APPLICATION: NON-MATERIAL AMENDMENT

SITE ADDRESS: Land North of Felpham, Bognor Regis

PLANNING PORTAL REFERENCE: PP-09199991

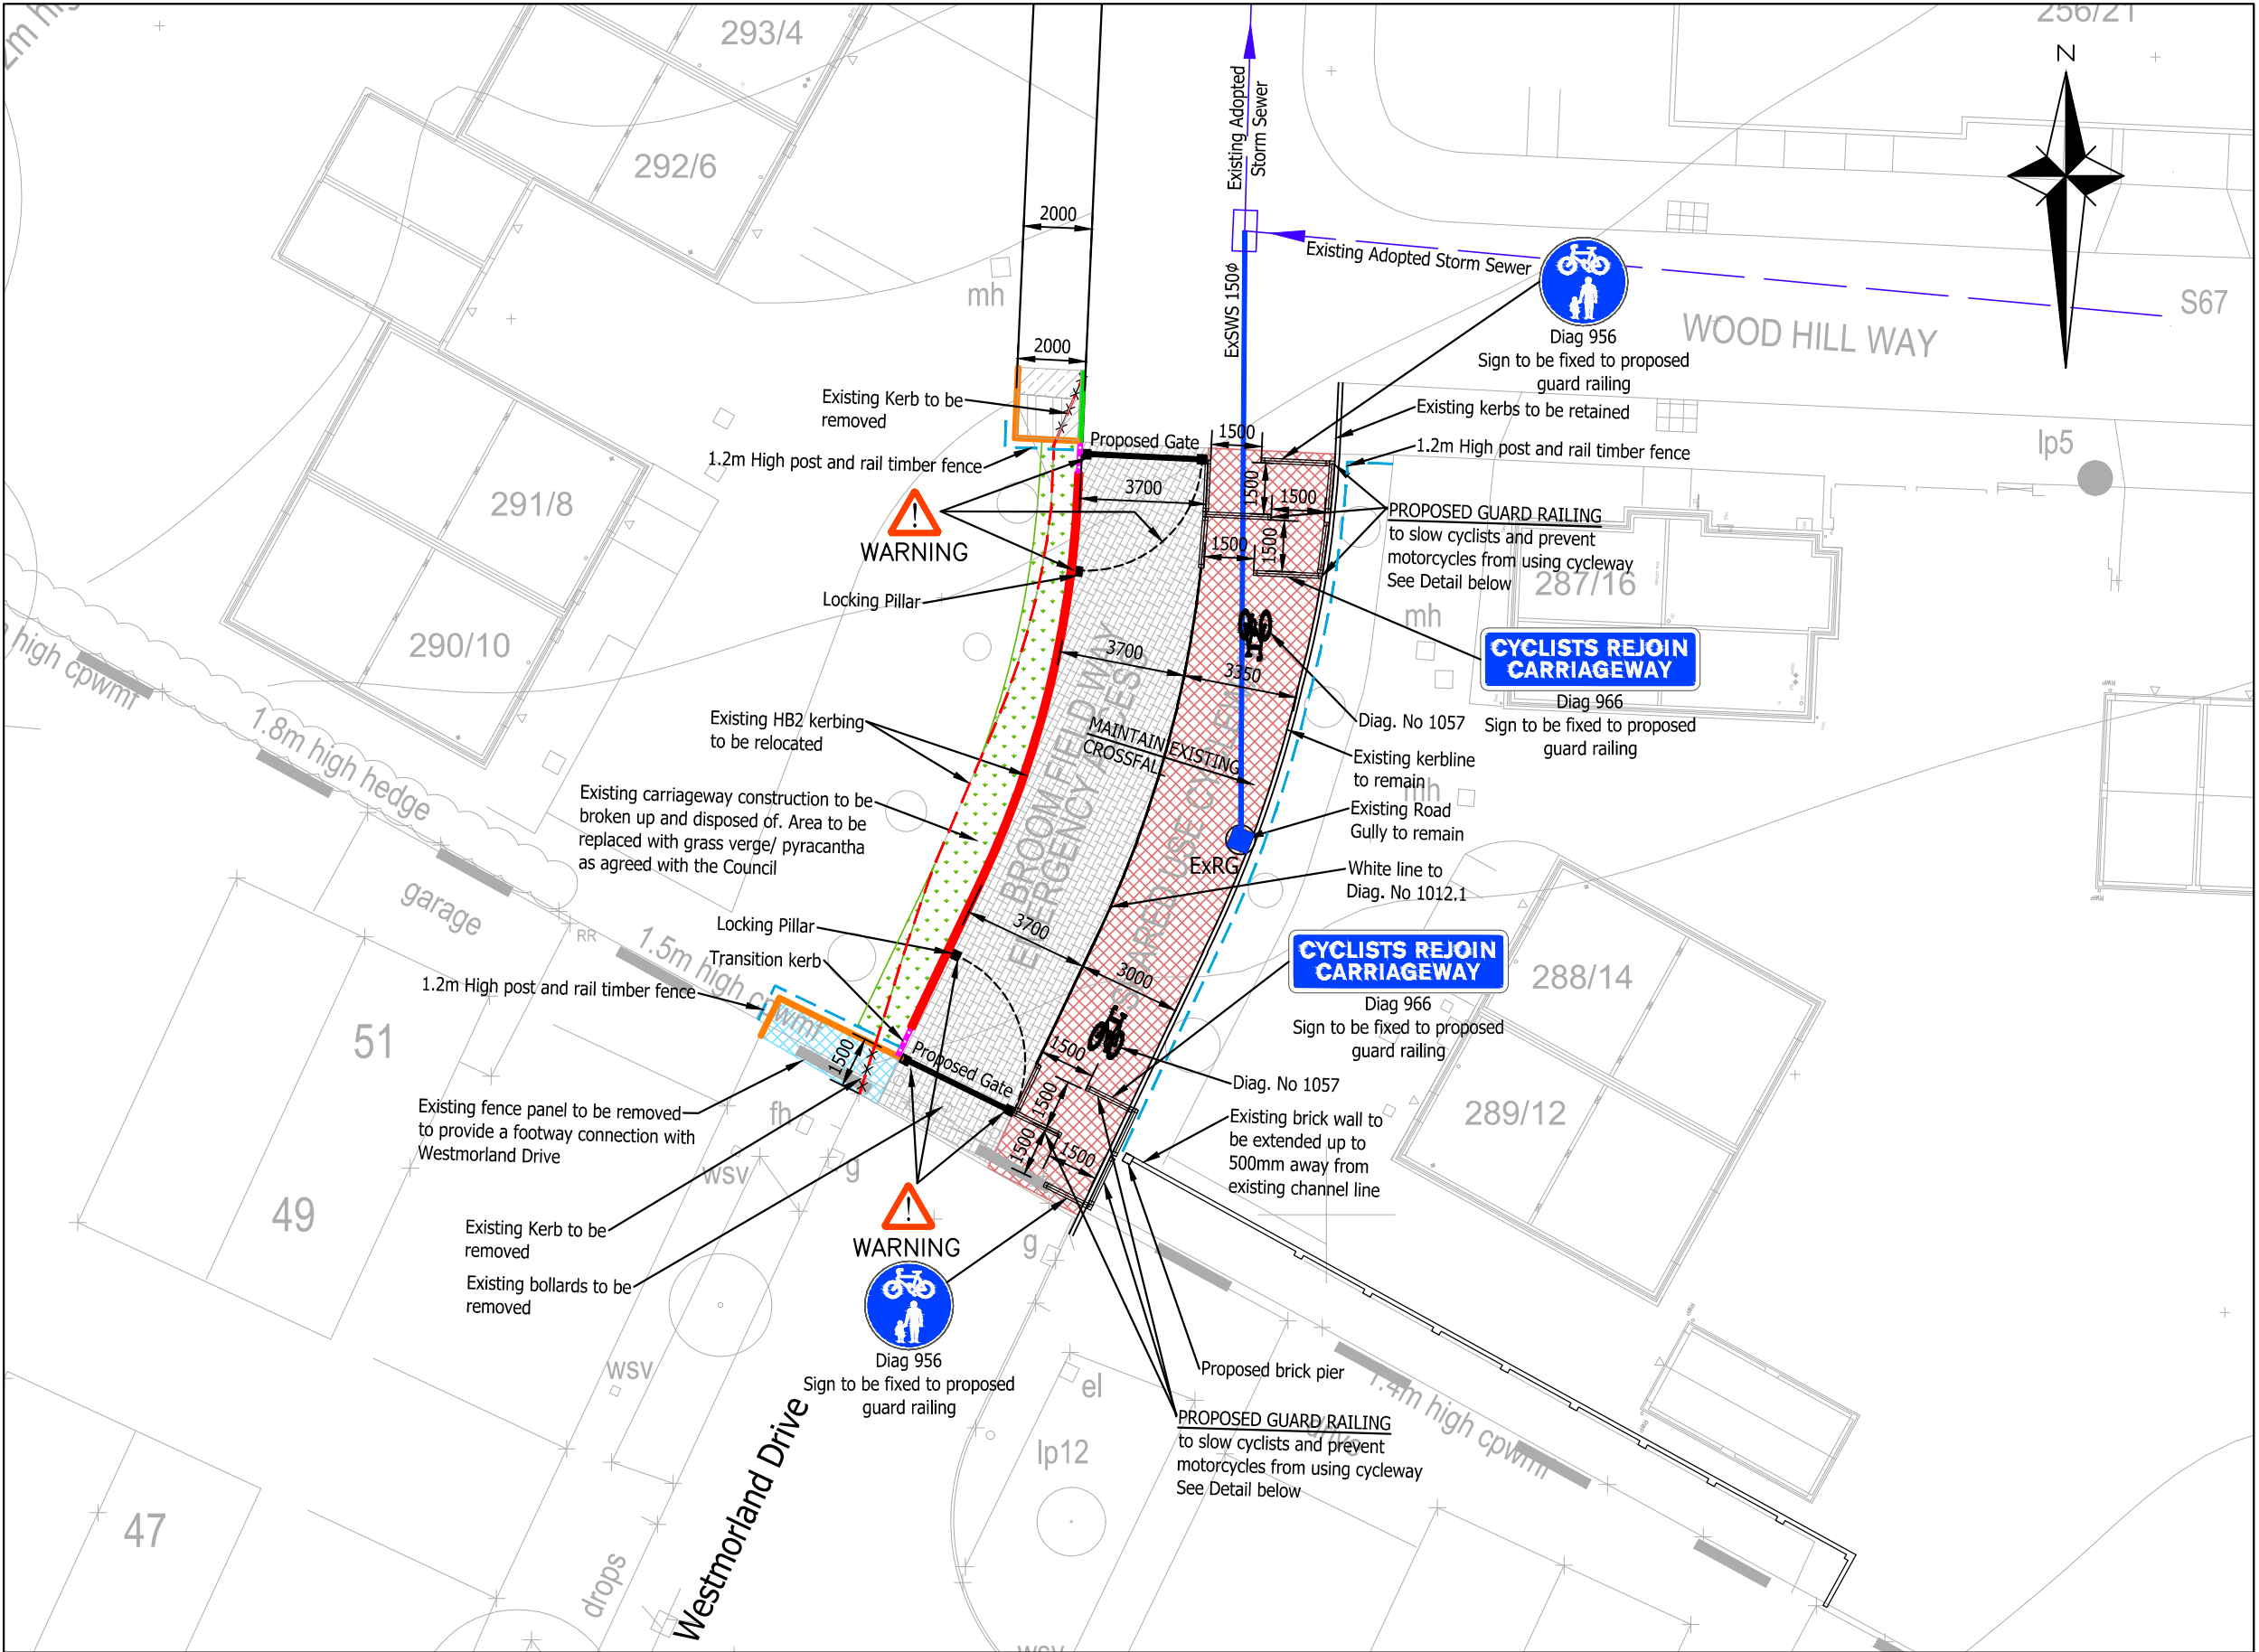
Permission FP/239/19/PL granted the replacement of the previously approved bus gate with a cycle access way. Relative to the previous consent, the current application seeks the following non-material amendments to the cycle access way:

- Replace small section of 1.2m close board fence with 1.2m post and rail fence
- Addition of guard railings adjacent to northern gate
- Gate colour to be amended from grey to yellow
